**Consultation Response from: KC Environmental Health (Pollution & Noise Control)**
**2023/90076 - Units A & B, Leeds Road Retail Park, Leeds Road, Huddersfield, HD1 6PF**
**Erection of store entrance and entrance canopy, formation of trolley bays, external alterations including additional glazing, block up existing entrances, formation of new entrances, associated remedial works on rear elevation, formation of improved pedestrian access from Bradley Mills Road, reconfiguration of customer car park and parking spaces and associated landscaping works**
**Responding Date:  
06 July 2023**
**Responding Officer:  
Mohammed Nasim**
**Responding Ref:  
WK202318625**

date **April 2021**
status **Planning**
scale **1:500 @ A3**
drawn **BM** checked **PH**
job no. **2905** dwg no. **P403** rev. **H**

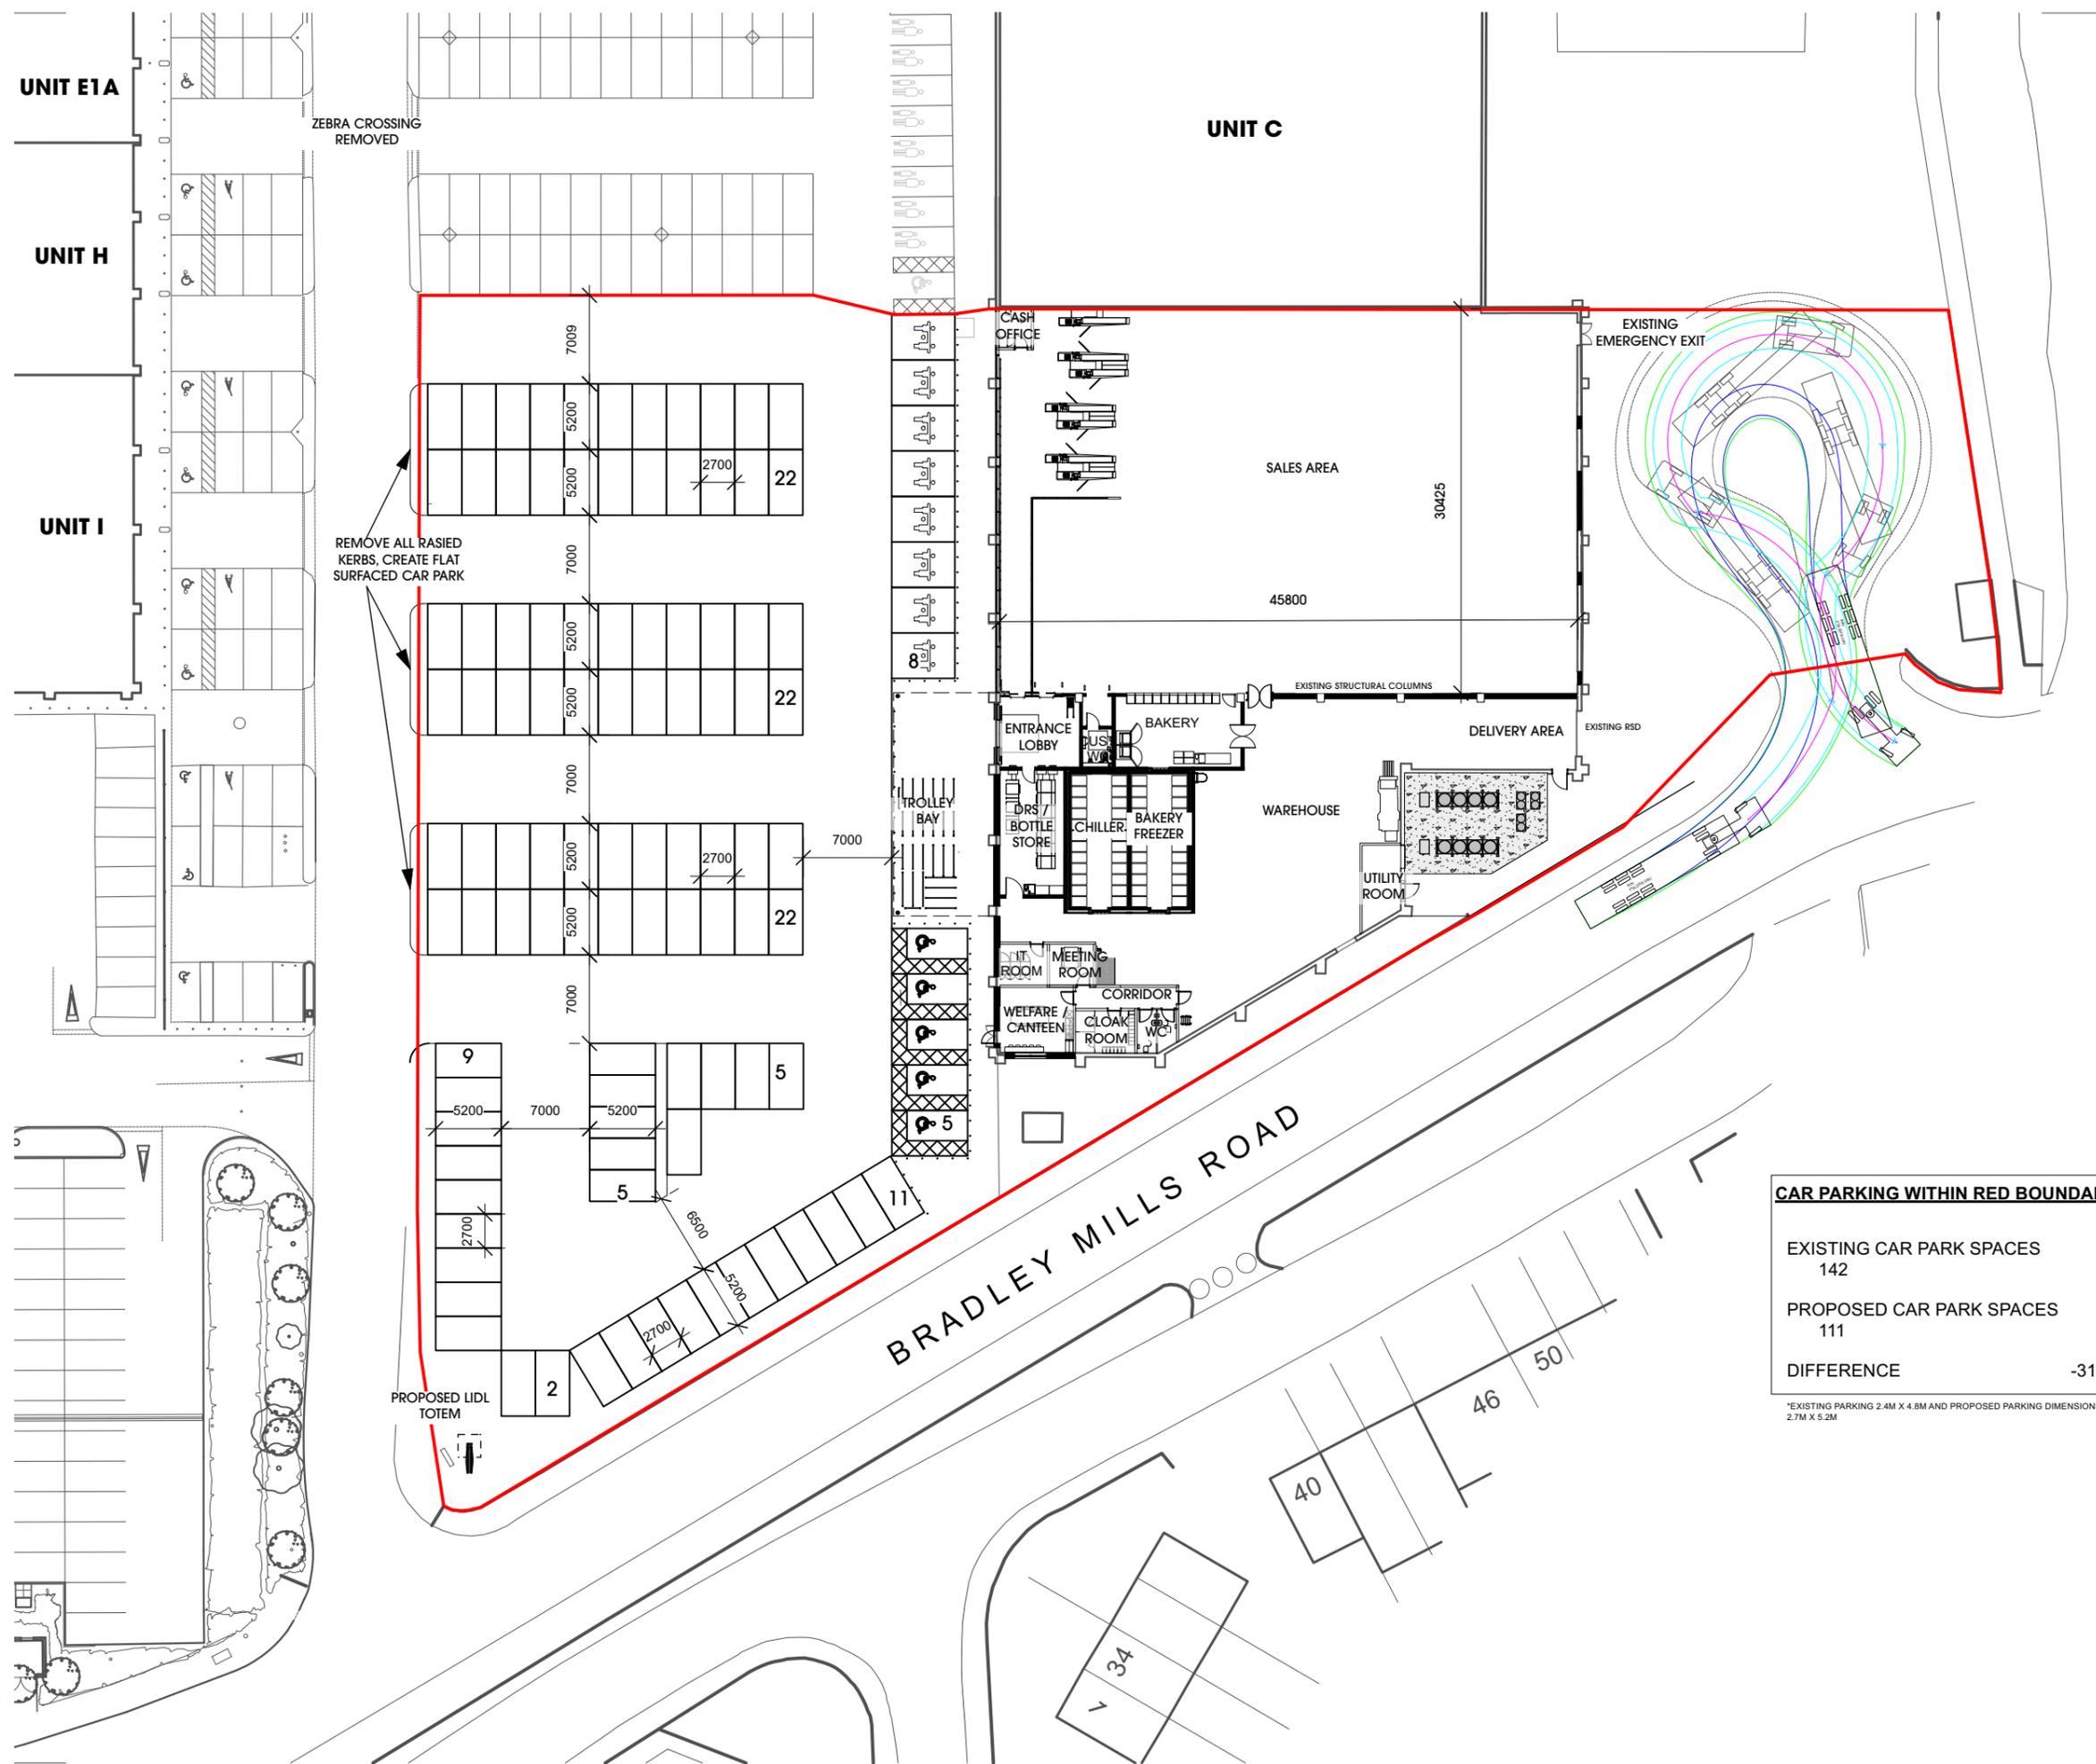
2. The proposed site plan from htc architects dated April 2021 Ref P403 shows 111 proposed car parking spaces. In accordance with the West Yorkshire Low Emission Strategy (WYLES) document we would ask for 10% of all unallocated parking spaces to be electric charge points. The applicant proposes to install 2 electric vehicle charging bays and this would only be acceptable if they are 'fast/rapid chargers'. An updated plan to show their location would be required.

**Recommended Conditions**
**EVC1 Electric Vehicle Charging Points - Condition**

Before the electrical system is installed, a scheme detailing the dedicated facilities that will be provided for charging electric vehicles and other ultra-low emission vehicles shall be submitted to and approved in writing by the Local Planning Authority. The scheme shall meet the requirements of the current West Yorkshire Low Emission Strategy (WYLES) document. The approved dedicated facilities for charging electric vehicles shall be installed prior to occupation and retained for use thereafter.
